DOC20/905735

2 November 2020

**St Marys Intermodal – Modification 1 –
Rail Siding Refurbishment Works Package (SSD 7308 Mod 1)
Advice on Modification**

Figure 6 | Rail refurbishment works engineering drawings – Sheet 02 of 05 (Source: Applicant's Modification Report)

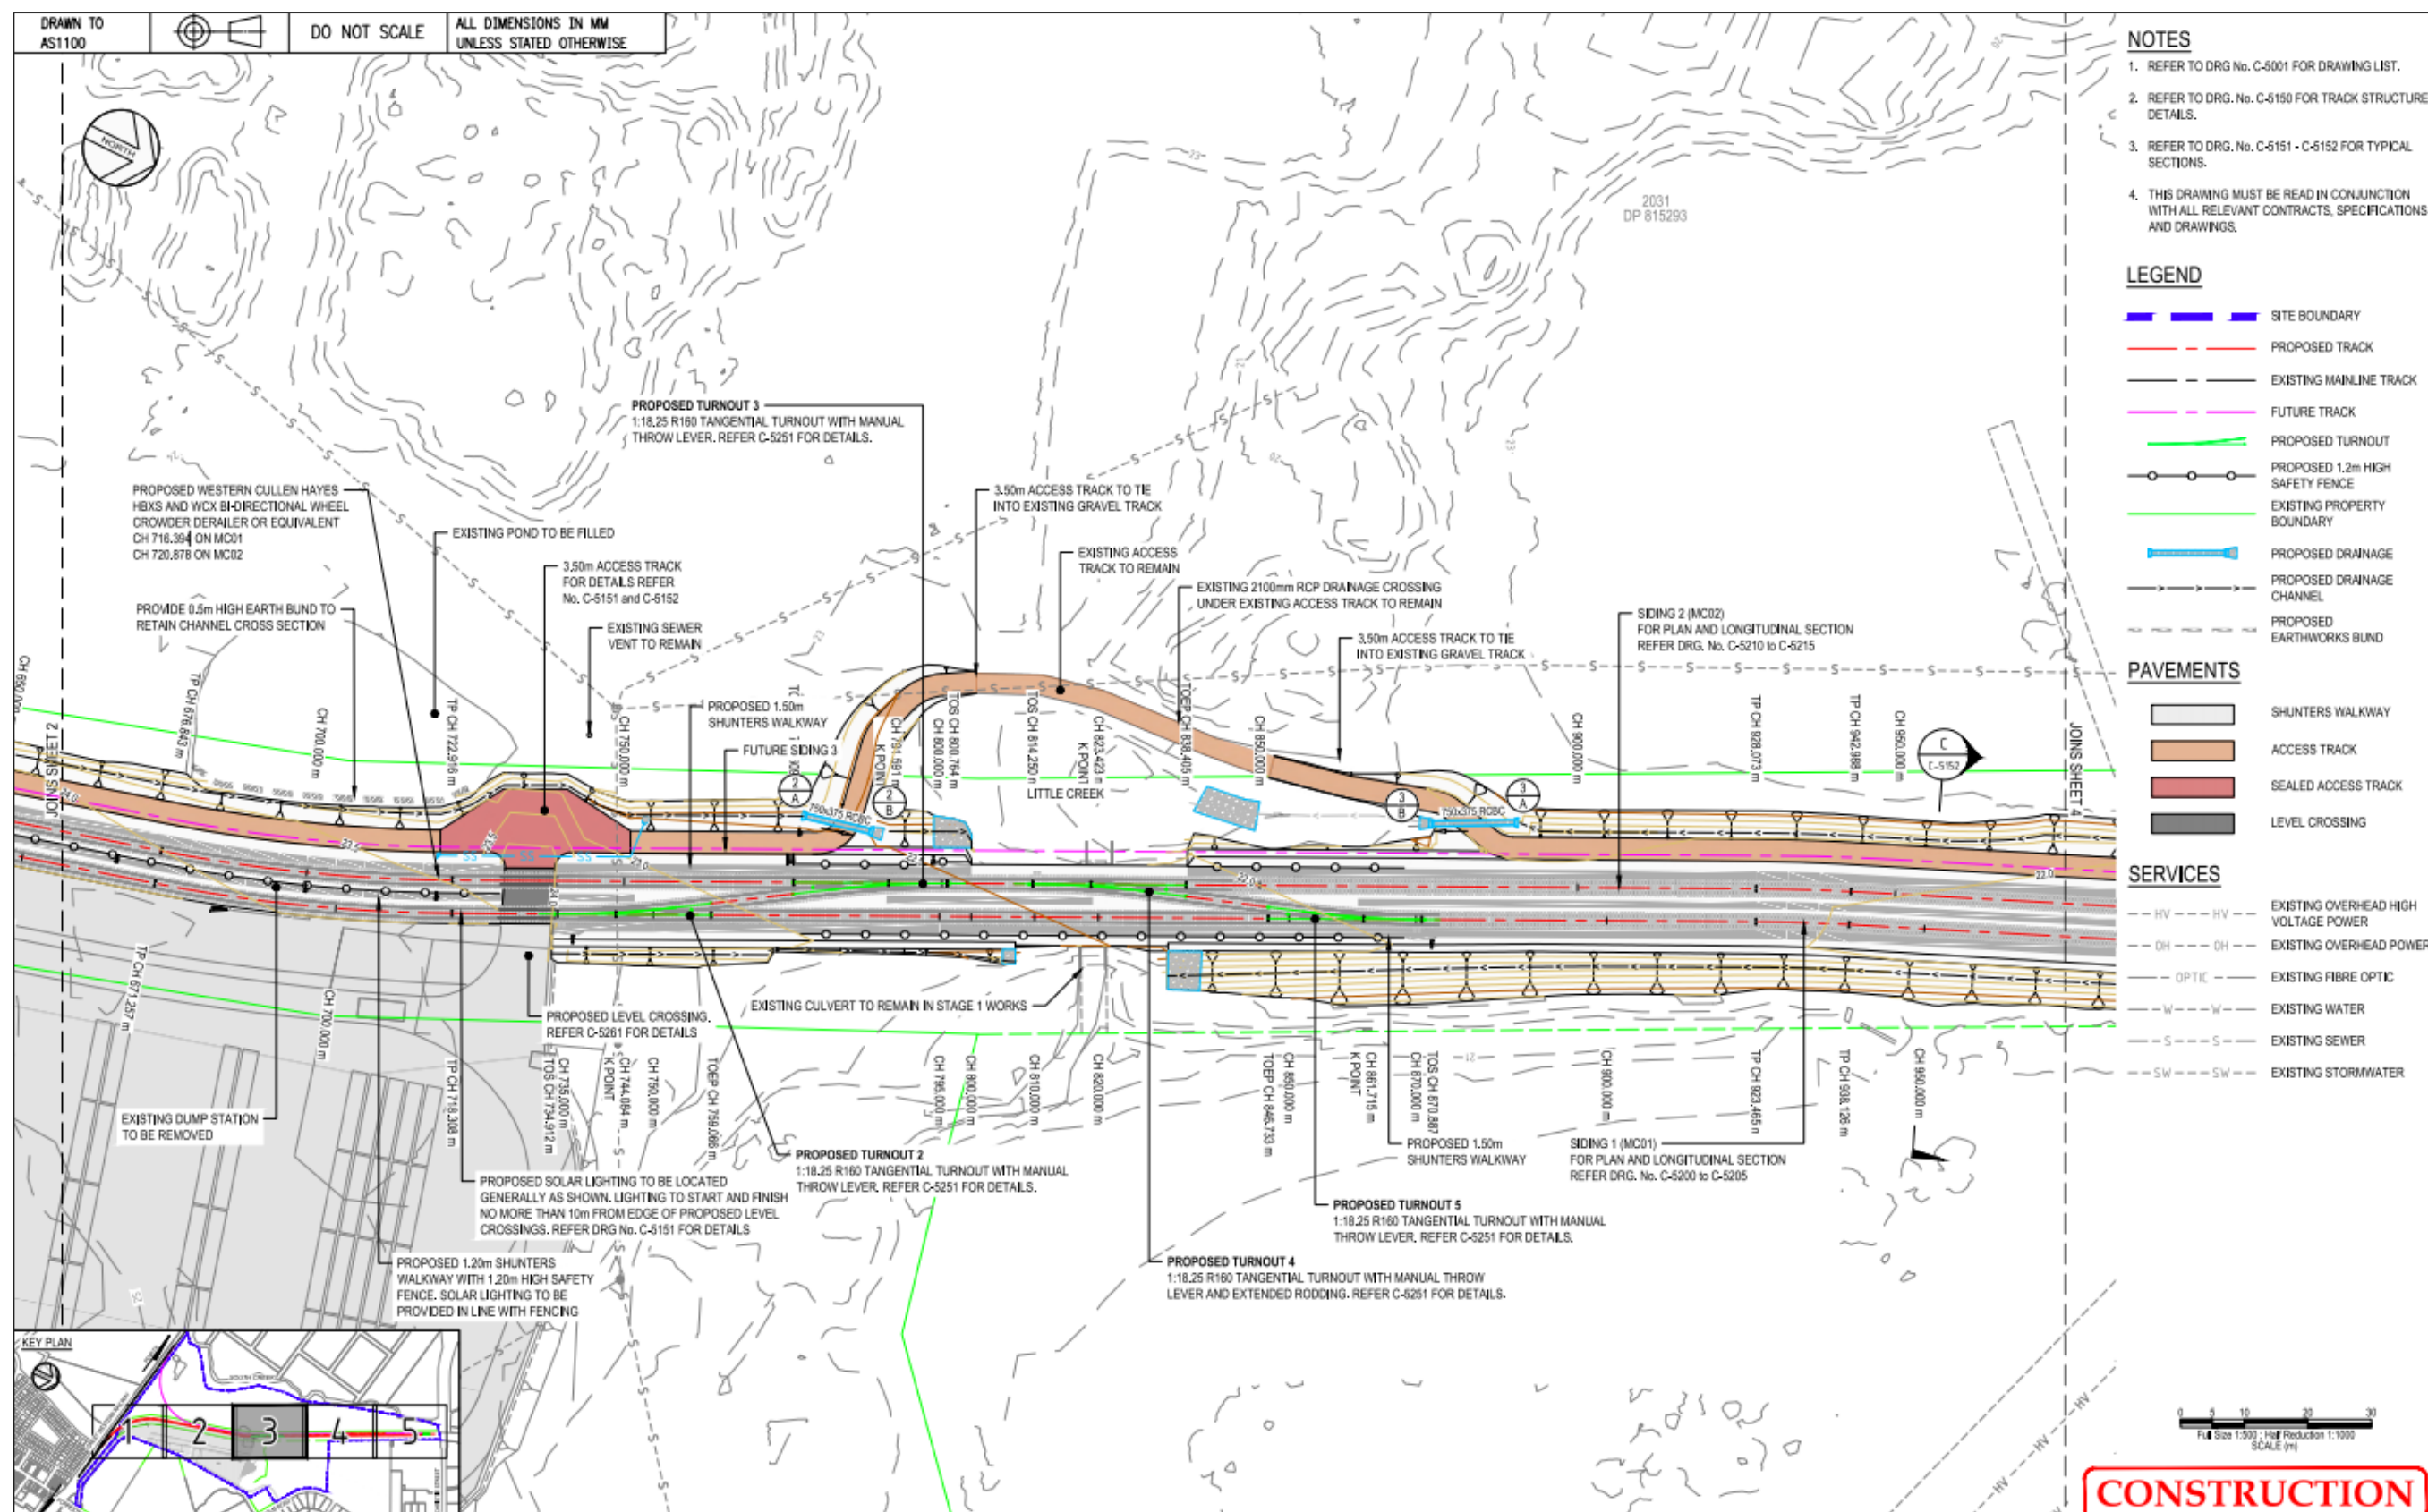
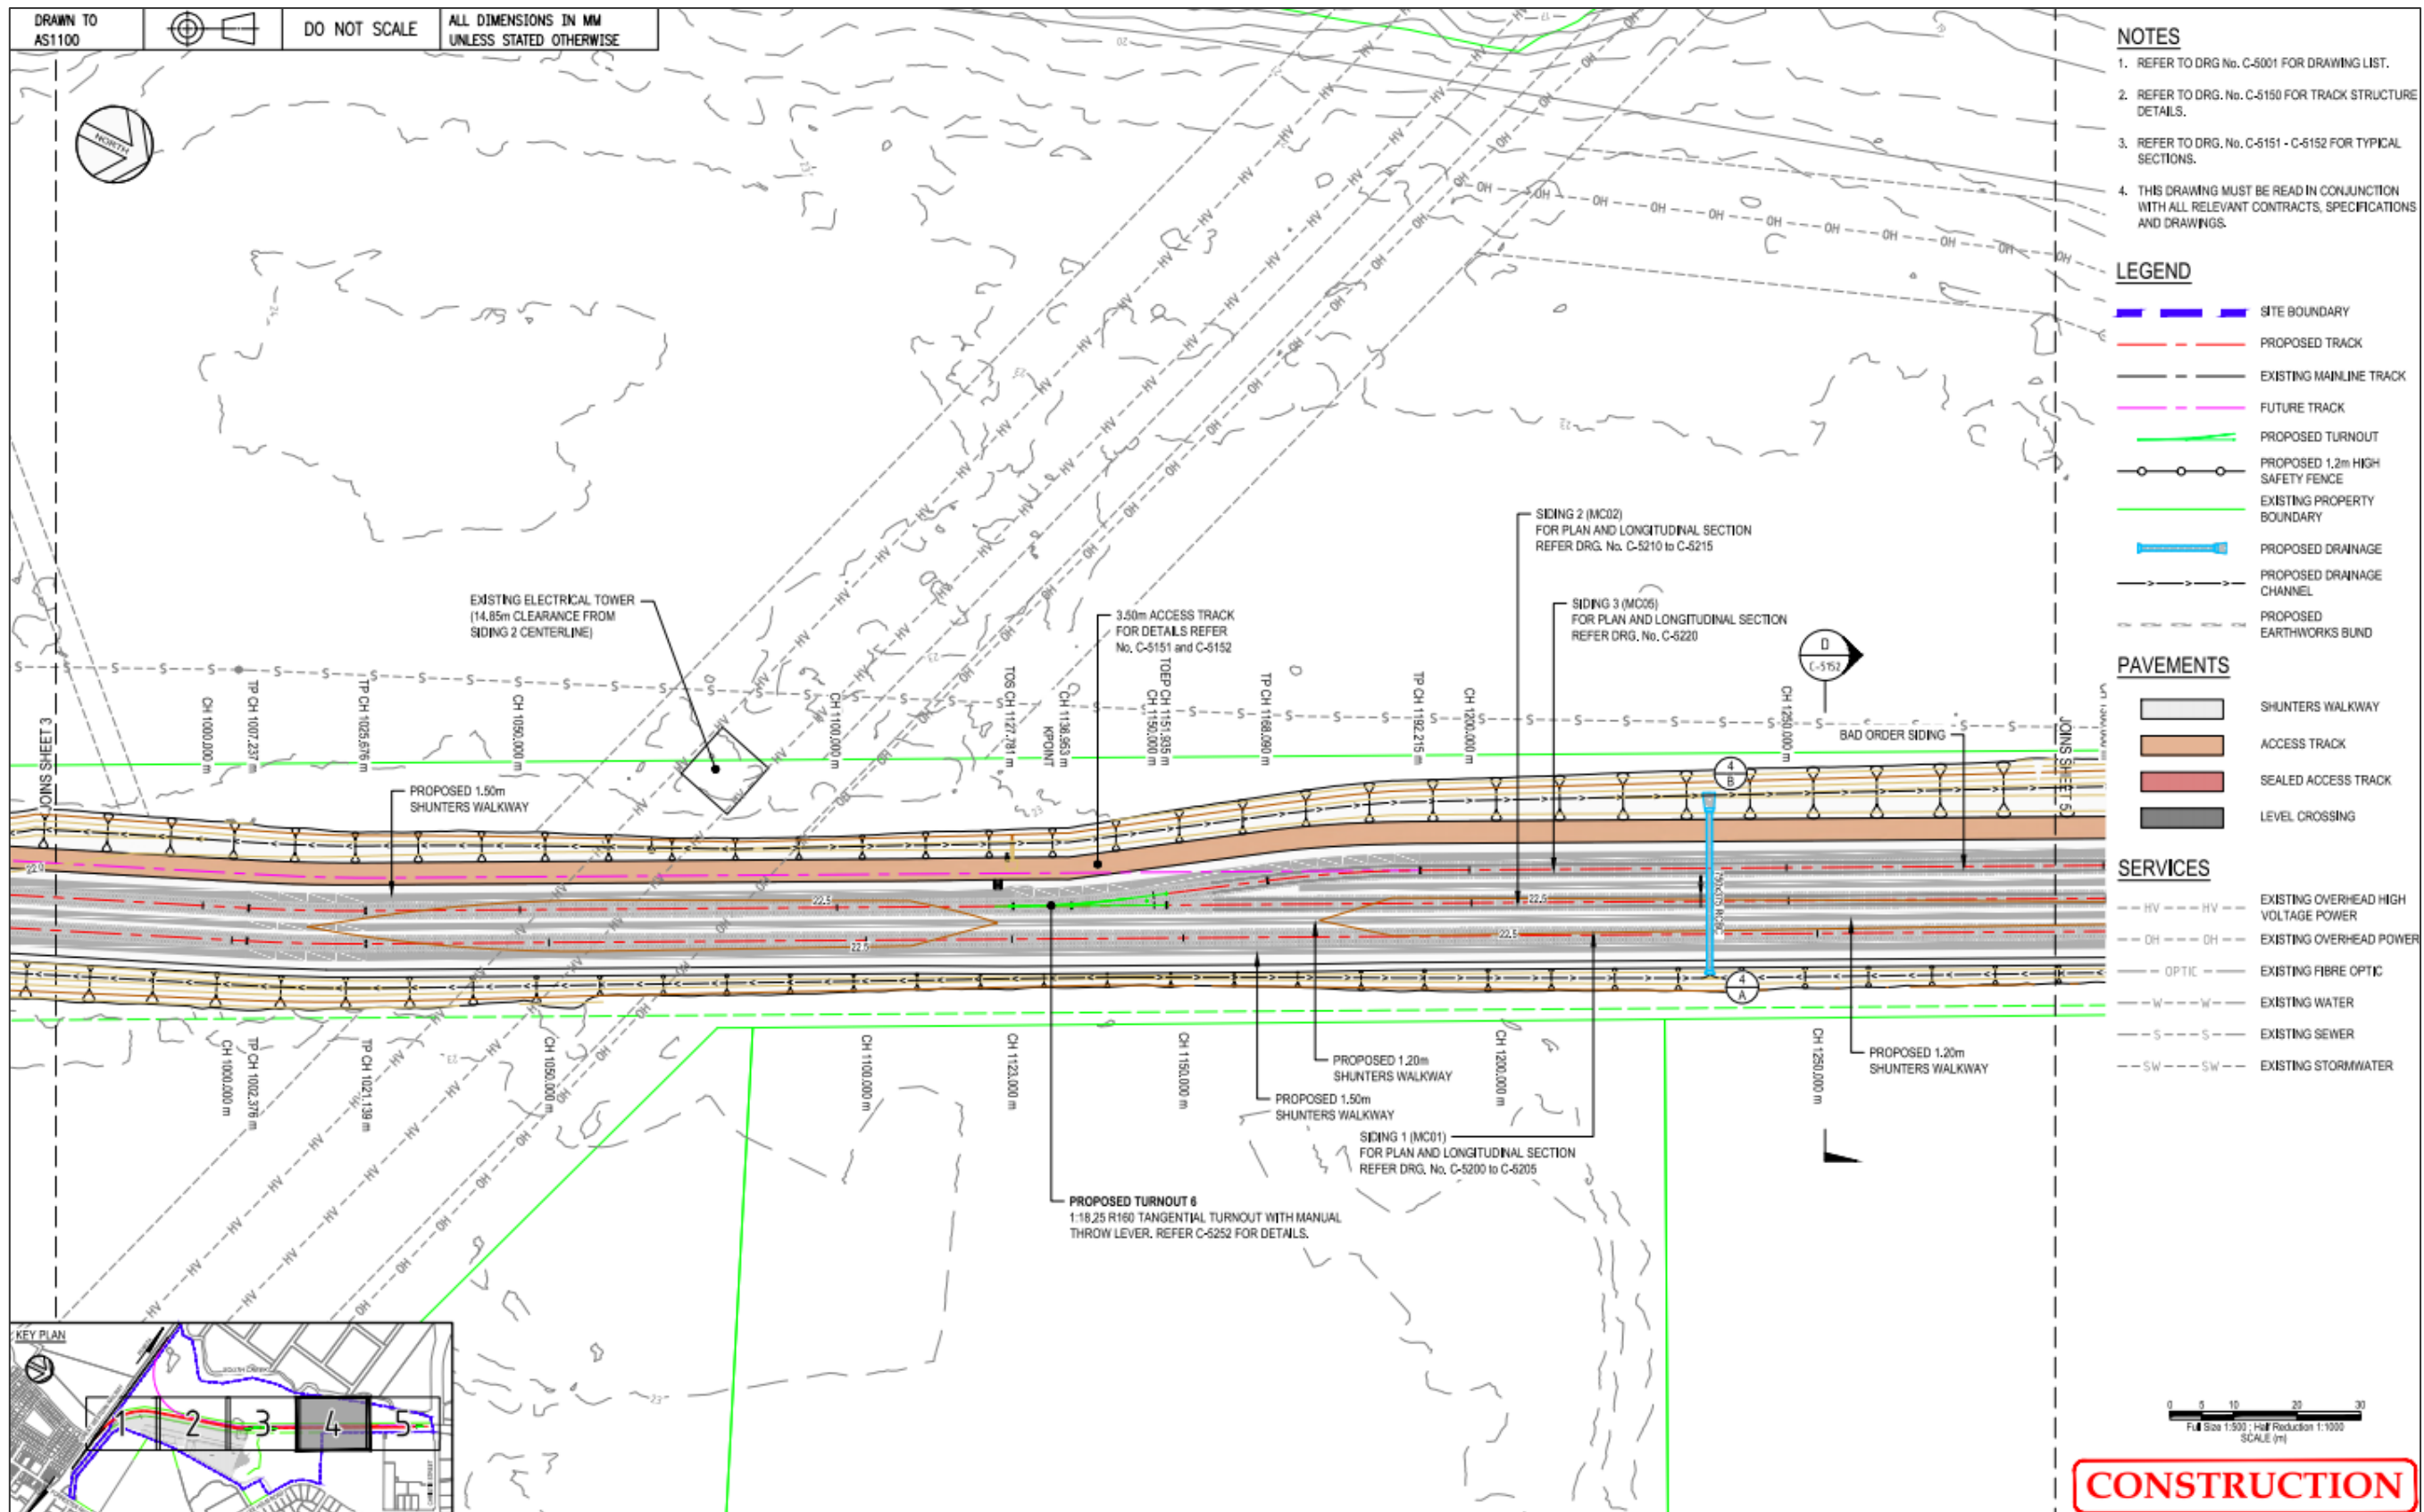
It appears that in the updated NIA, the section of the rail siding which extends north of the area considered in the EIS has been assessed using the provisions from the *Rail Infrastructure Noise Guideline* (EPA, 2013) (RING) for non-network rail lines.

However, it appears that siding will be used for shunting, switching and storage of trains as part of the intermodal facility and does not lead to other industrial premises. As such the EPA considers that the siding sections north of the intermodal are part of the industrial premises and should be assessed using the *Noise Policy for Industry* (EPA, 2017) (NPfI)

Appendix 3 of the RING states: *“Where a non-network rail line exclusively servicing one or more industrial sites extends beyond the boundary of the industrial premises, noise from this section of track should be assessed against the recommended acceptable LAeq noise levels from industrial noise sources for the relevant receiver type and indicative noise amenity area...”*

This was developed for situations where rail activities between the development site and the connection to a network line would be a discrete activity. In this instance, as described above, the sections of rail sidings north of the intermodal is not considered a discrete activity, but rather part of the industrial activities at the intermodal. Therefore, activities that occur on this section of the siding such as shunting, switching or storage should be considered part of the industrial activity at the premises and assessed using the NPfl in conjunction with all other operational noise sources.

The EPA recommends that sections of the siding north of the intermodal should be assessed in accordance with the *Noise Policy for Industry* (EPA, 2017) in conjunction with all other operational activities on the premises.

The original EIS noise impact assessment did not assess rail refurbishment of the whole length of the siding which is proposed to be refurbished in this modification. As such, the construction impacts presented in the modification documents do not appear to consider potential impacts generated by rail refurbishment in the areas proposed in this modification.

The EPA recommends that construction noise and vibration impacts generated by this proposal – that were not considered in the original EIS or other modifications – be assessed as part of this modification.
